Subject: Hydrant condition - FG/123/20/PL

HYDRANT CONDITION CONSULTATION WITH PLANNING AUTHORITY

Planning Ref: FG/123/20/PL

Address: Land at former McIntyre Nursery, Littlehampton, Road Ferring
BN12 6PG

STATUS	CLIENT		
Outline Design	Standby Self-Storage		
SCALES	DATE	SIZE	
1 : 200	Sept 2020	A2	
TITLE			
PROPOSED SITE & BLOCK PLAN			
DWG NO			REV
5320-2		d

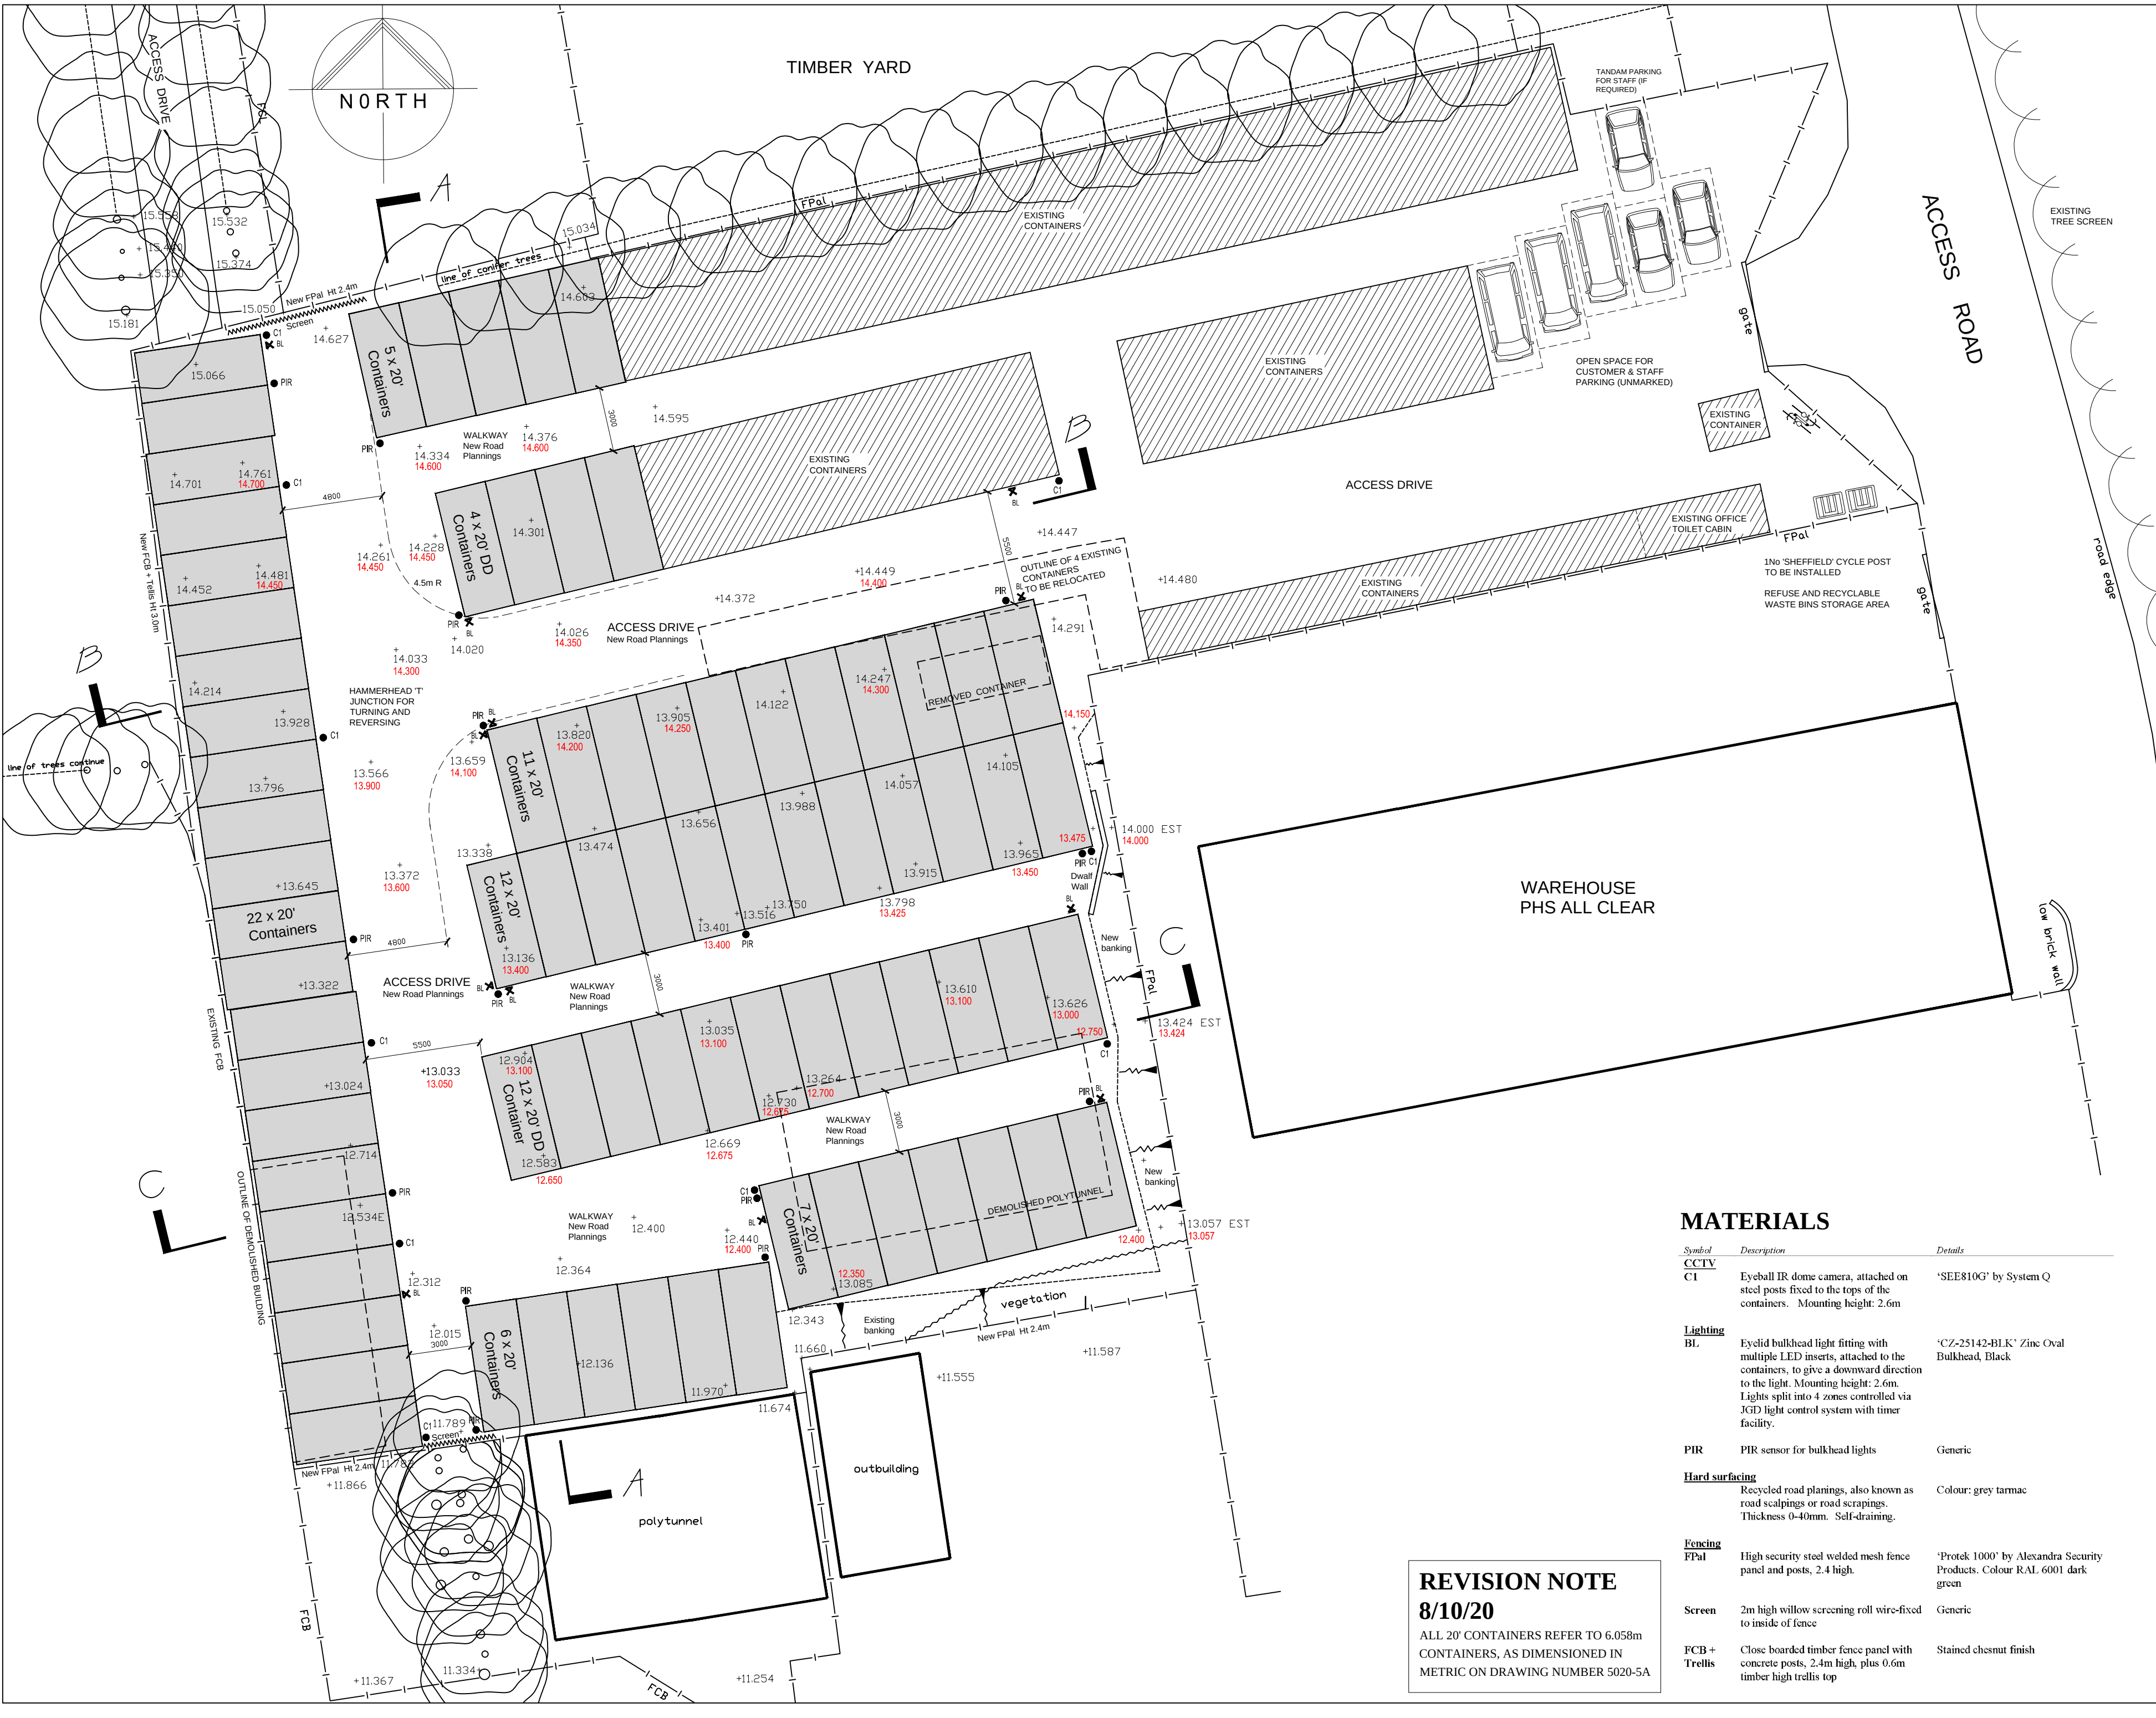
Please find attached a planning condition for application no. FG/123/20/PL for the requirement of an additional fire hydrant. Currently the nearest Hydrant to these proposed properties is 280 metres away. The supply of water for firefighting for a commercial premises should be within 90 metres.

Evidence will also be required that Fire Service vehicle access meets with the requirements identified in Approved Document B Volume 1 2019 Edition: B5 Section 13, including Table 13.1 and diagram 13.1.

- 1) Prior to the commencement of the development details showing the proposed location of [1] one fire hydrant or stored water supply (in accordance with the West Sussex Fire and Rescue Guidance Notes) shall be submitted to and approved in writing by the Local Planning Authority in consultation with West Sussex County Council's Fire and Rescue Service. These approvals shall not be unreasonably withheld or delayed.
- 2) Prior to the first occupation of any dwelling/unit forming part of the proposed development that they will at their own expense install the fire hydrant (or in a phased programme if a large development) in the approved location to BS 750 standards or stored water supply and arrange for their connection to a water supply which is appropriate in terms of both pressure and volume for the purposes of firefighting.
